State Significant Development Application and Variation of the Sydney Cove Redevelopment Scheme for the 'Remediation, Renewal and Adaptive Re-Use of Campbell's Stores', The Rocks (SSD 7056)

My second submission is an objection on **HERITAGE** grounds in relation to:

Drawing Title  
**HICKSON ROAD LEVEL 01 PLAN**  
Drawing Number  
**12006**  
Drawing Status  
**EA**  
Drawing Number  
**EA-A-1002**  
Revision  
**B**

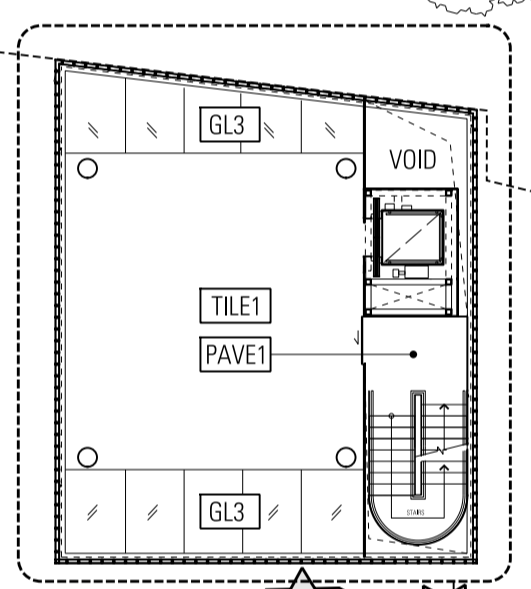
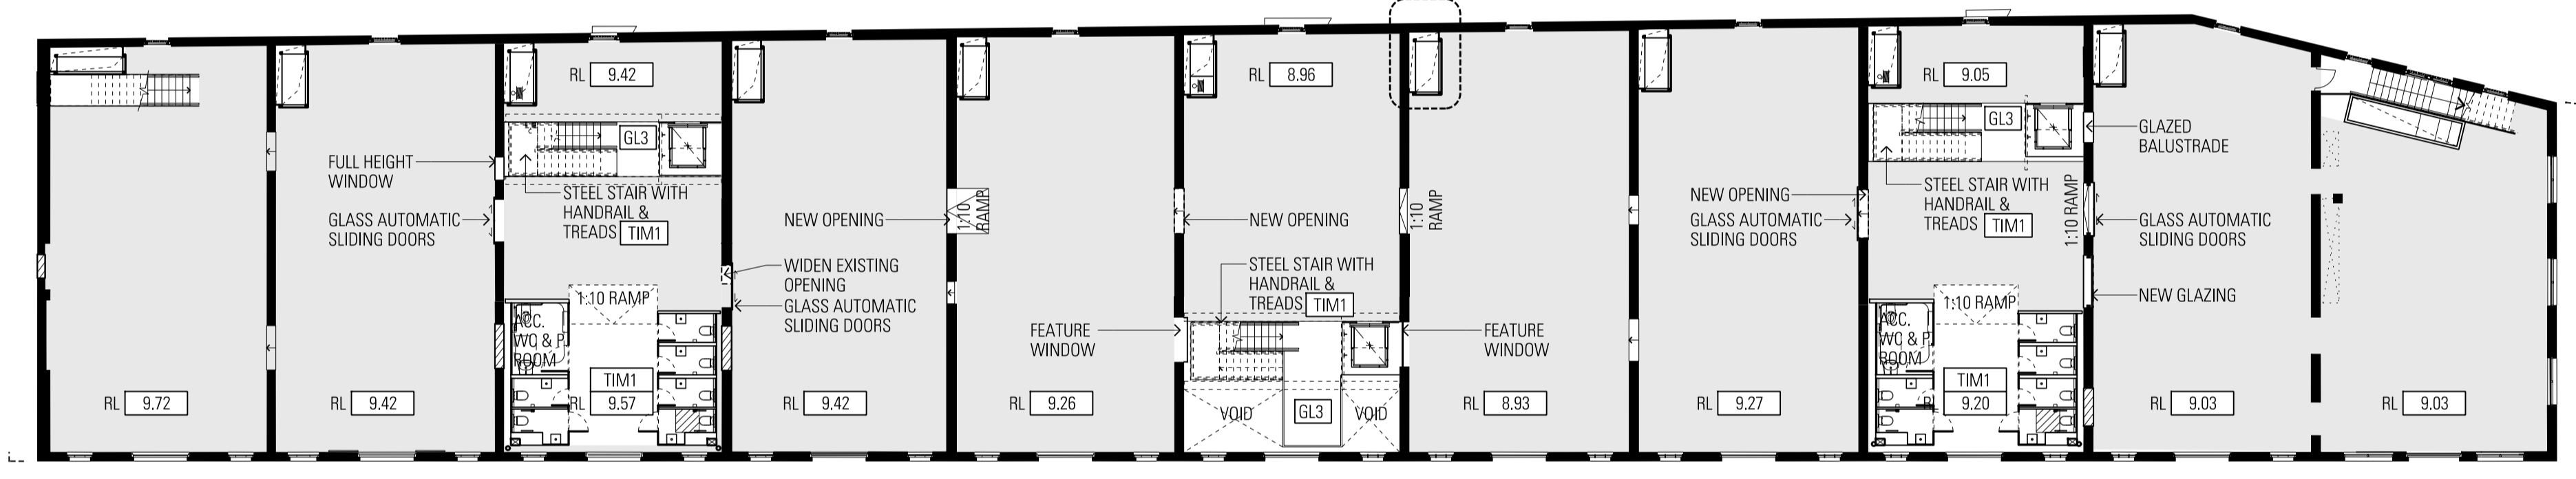
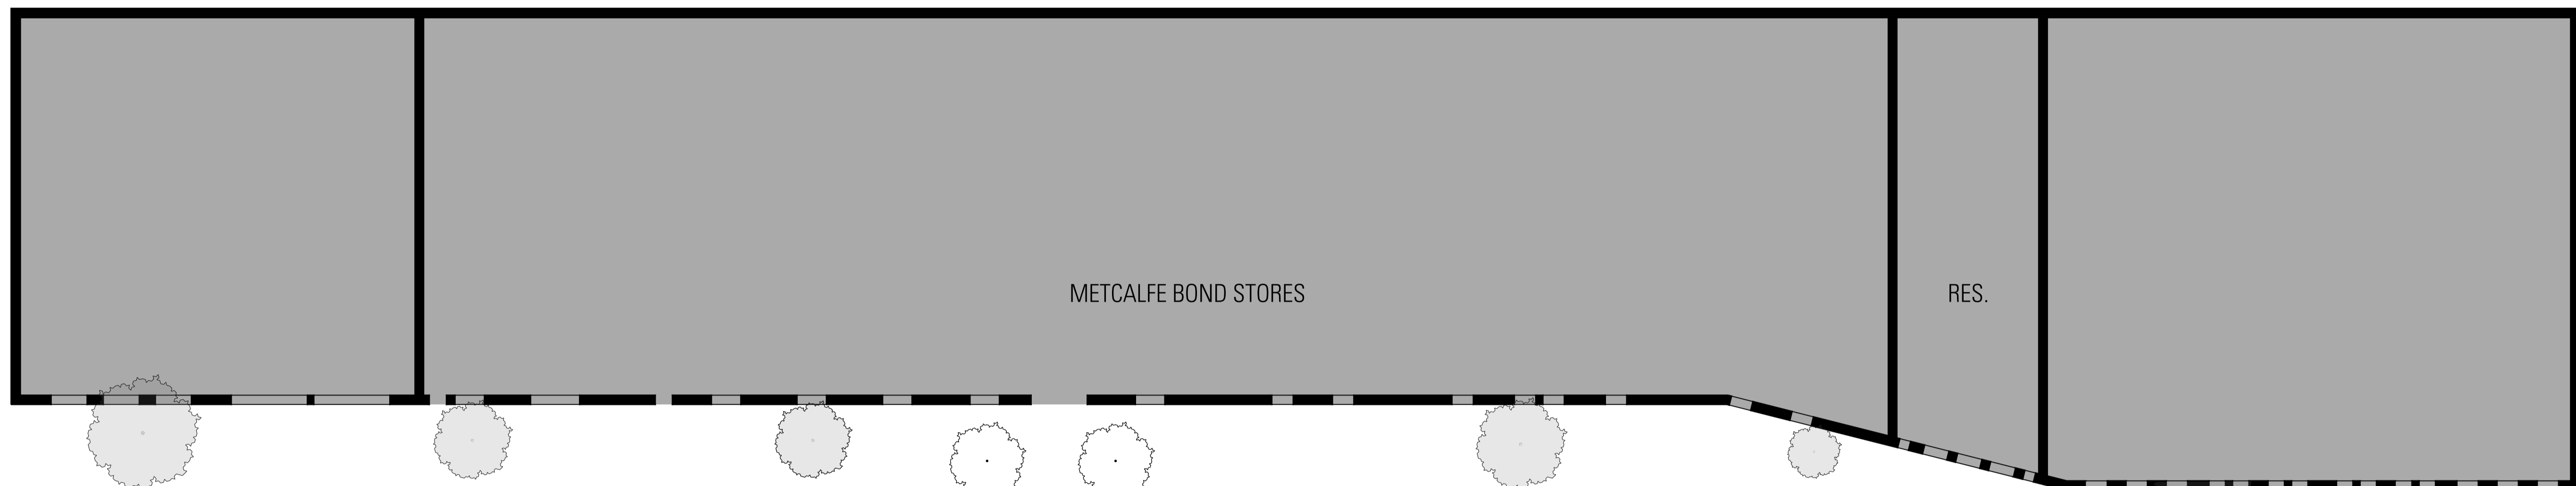
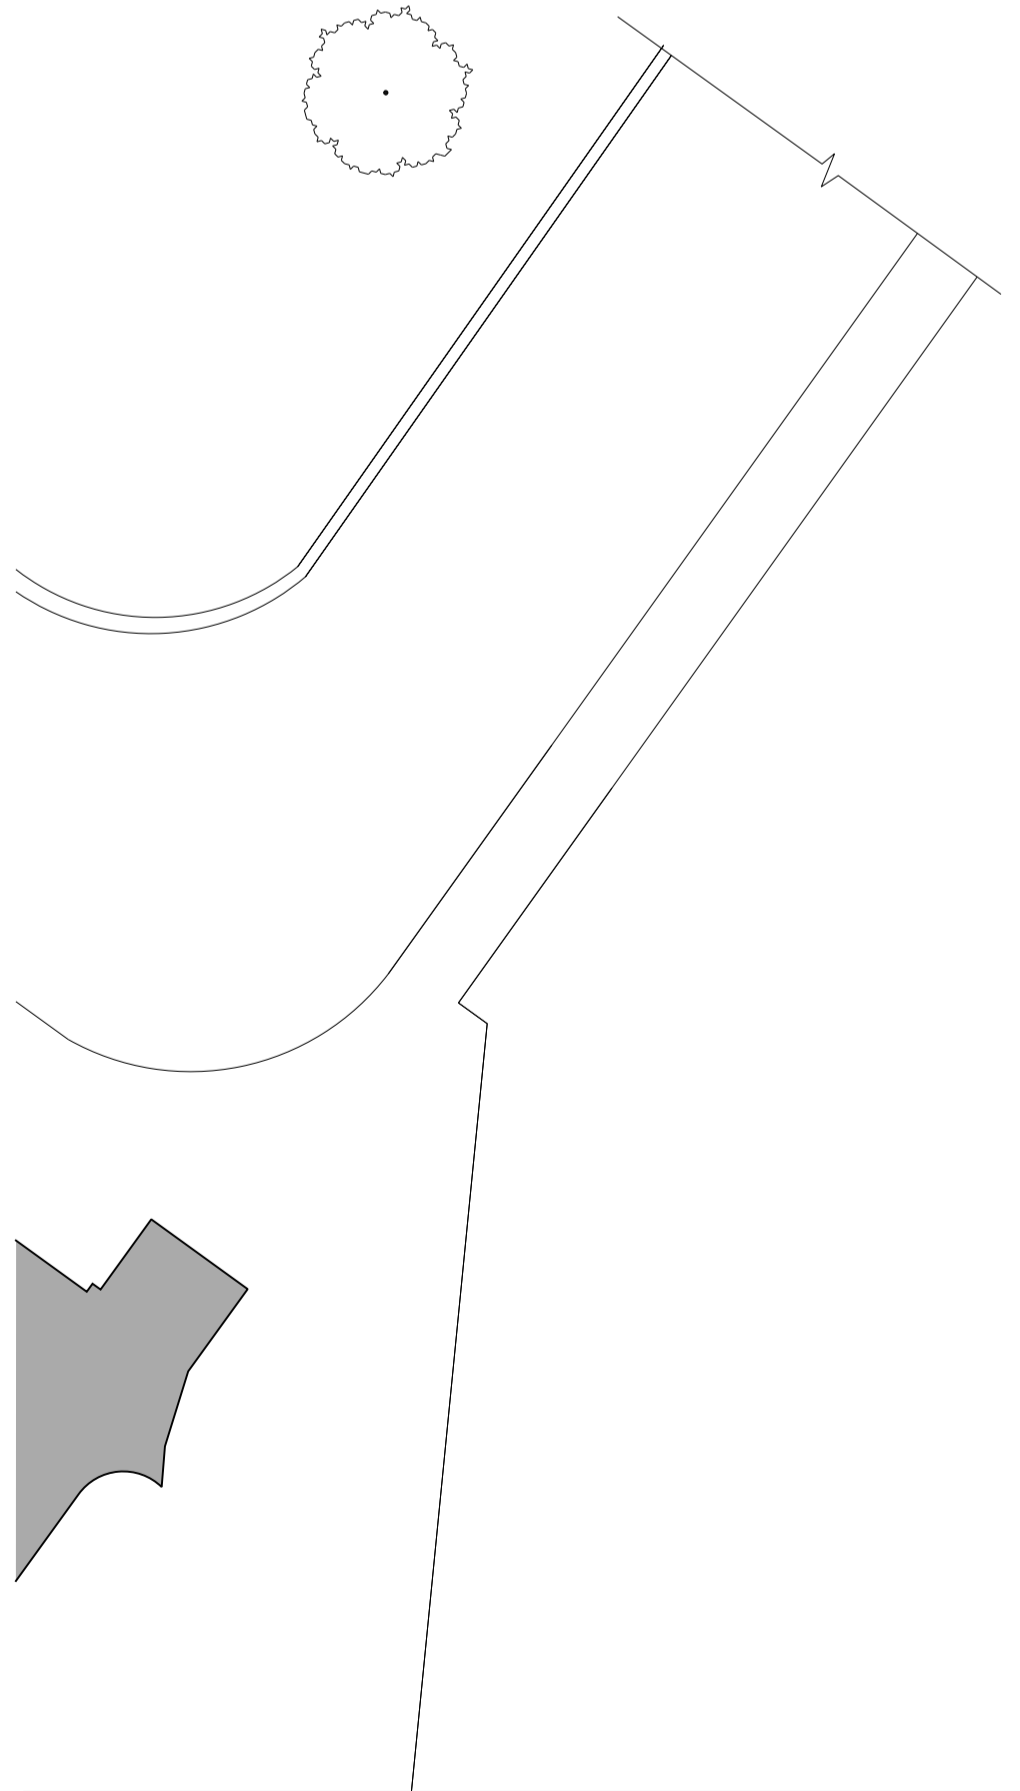
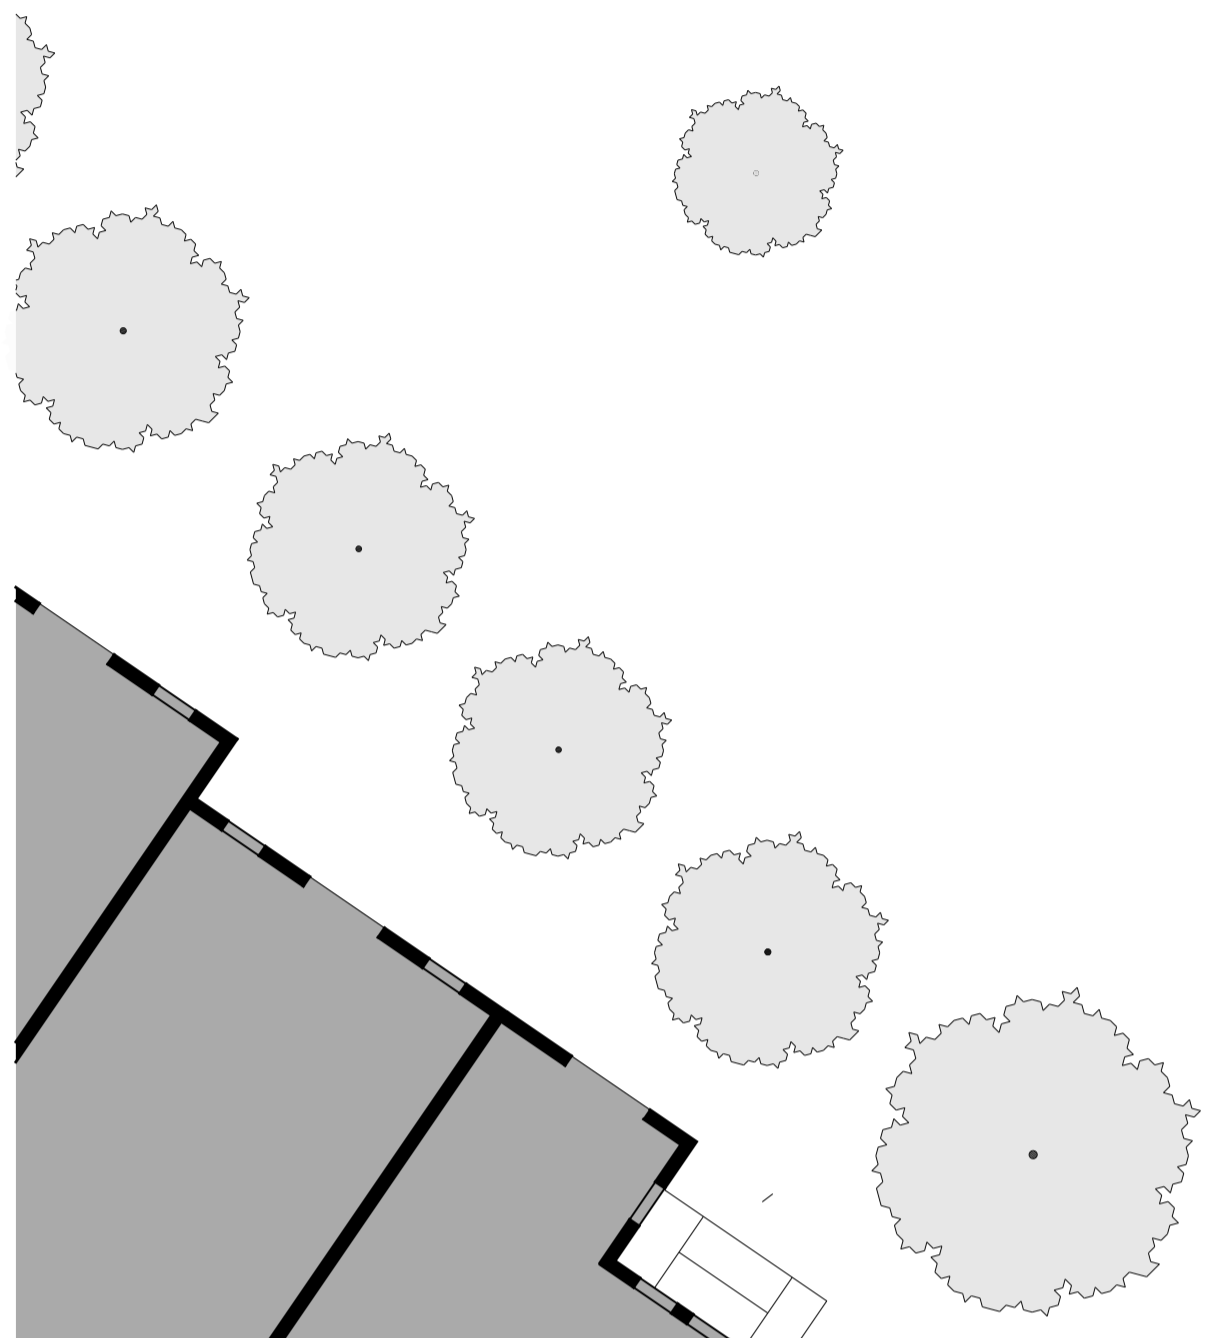
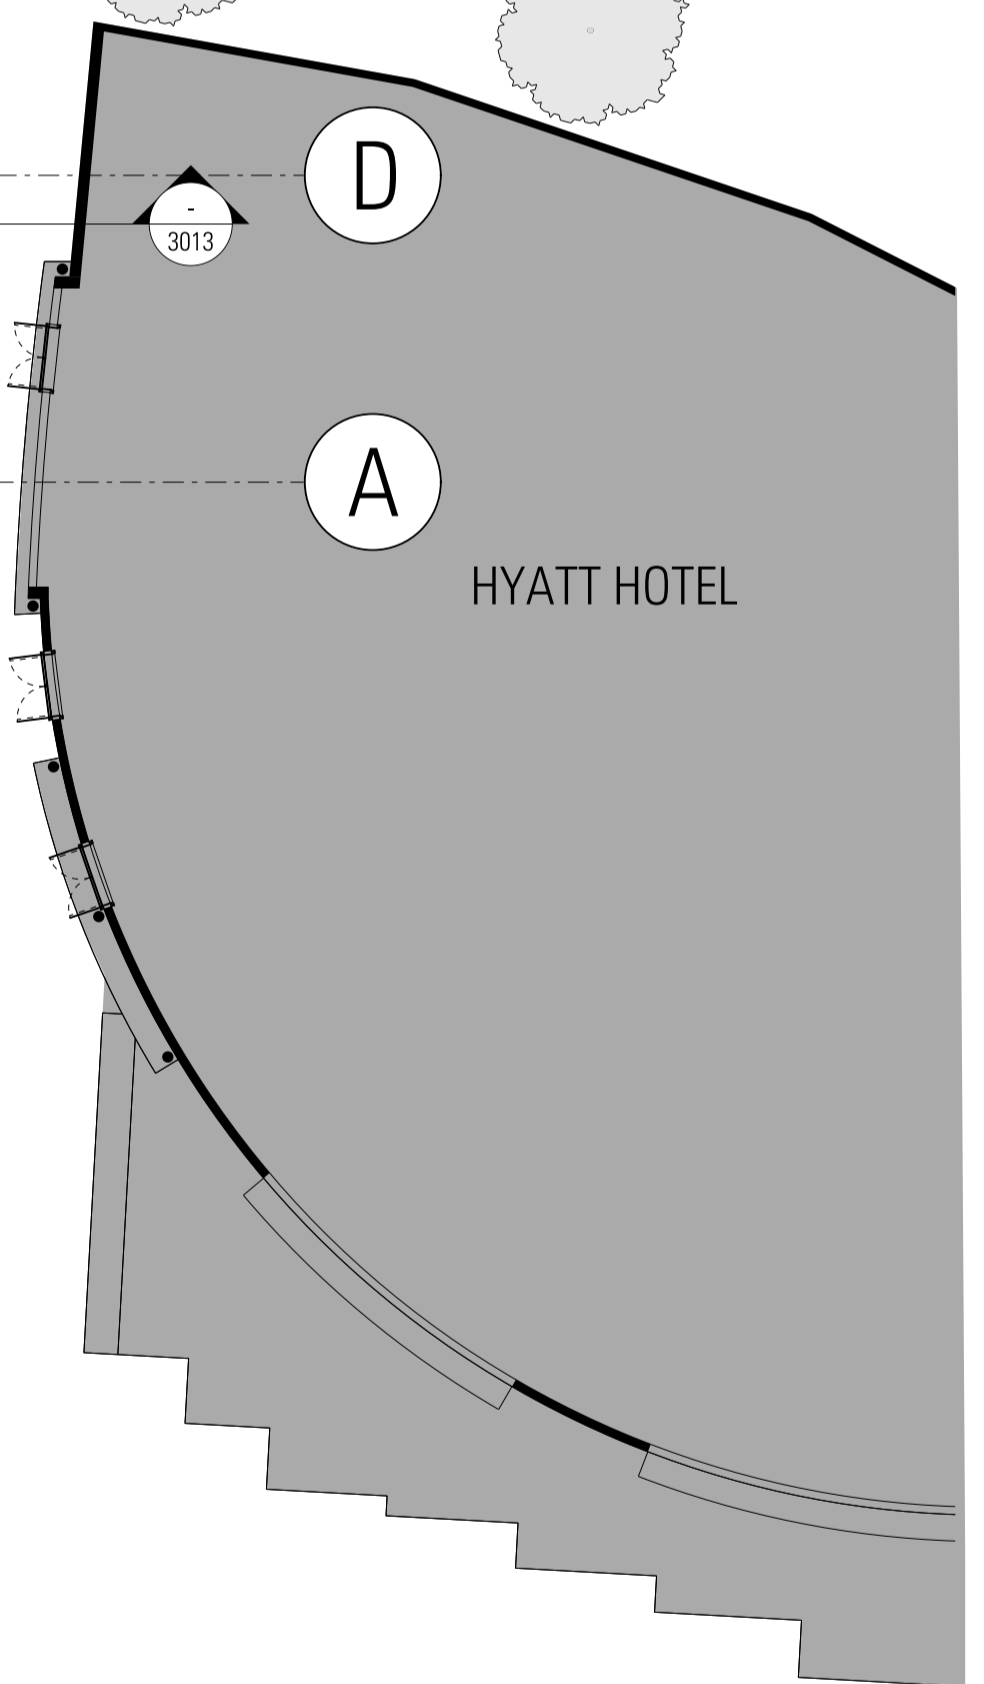
- widening of the existing c.1915 openings on the Hickson Rd frontage to create three new and much larger concrete entry portals. Creating these openings will destroy sections of the building's early sandstone brickwork and the end product will encroach upon the City of Sydney's existing pedestrian footpaths. The openings will all have back-lit signs and the centre opening will cut right through the building further damaging its original fabric.

- the creation of outdoor eating areas, with chairs, tables and umbrellas on Hickson Rd. While this is an appealing image, it would reduce visibility to this (western) side of the Stores and limit people's opportunity to appreciate the building's original form and function. This western elevation is the side that is most in keeping with the original form of Campbell's Stores and the one that most reveals the Stores' 19th century character. To maintain its heritage significance, this façade needs to be kept intact as much as possible.
